February 10, 2012

Harnett County Government Complex
307 Cornelius Harnett Boulevard
Lillington, NC 27546

RE: Harnett County Land Use Existing Tank Application #12-5-28264

SITE PLAN APPROVAL

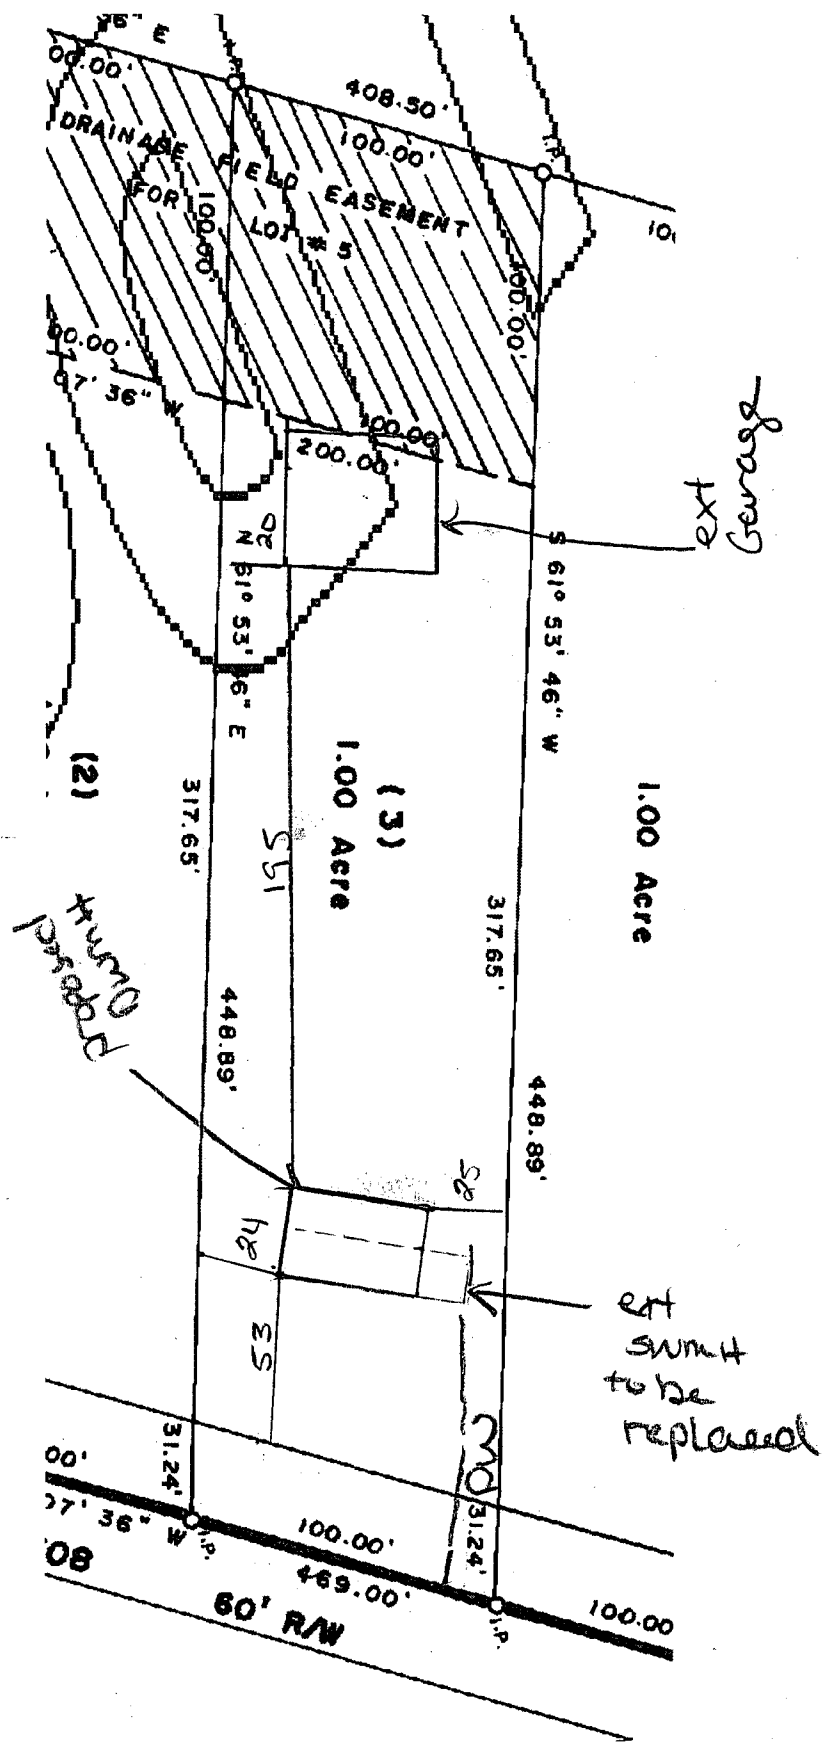
Based on the criteria set out in Title 15A, Subchapter 18A, of the North Carolina Administrative Code, Rules .1950, the evaluation indicated that the site is **UNSUITABLE** for the addition requested. Therefore, your request for an existing tank is **DENIED**. The site is denied based on the following:

- 15A NCAC 18A.1950a {16} - Any swimming pool must be 15' from any part of septic system.
- 15A NCAC 18.1945{b} - Each lot shall have original septic system plus repair area.
- 15A NCAC 18A.1950 {10} - Any building to be 5' from drain line.
- 15A NCAC 18A.1950{c} - Nitrification fields and repair areas shall not be located under paved areas or areas subject to vehicular traffic.

If you should have any questions or concerns I can be contacted Monday through Friday from 8am – 9am at 910-893-7547. **You will need to change your setbacks and revise your application and resubmit to Central Permitting's office before I can re-evaluate your lot.**
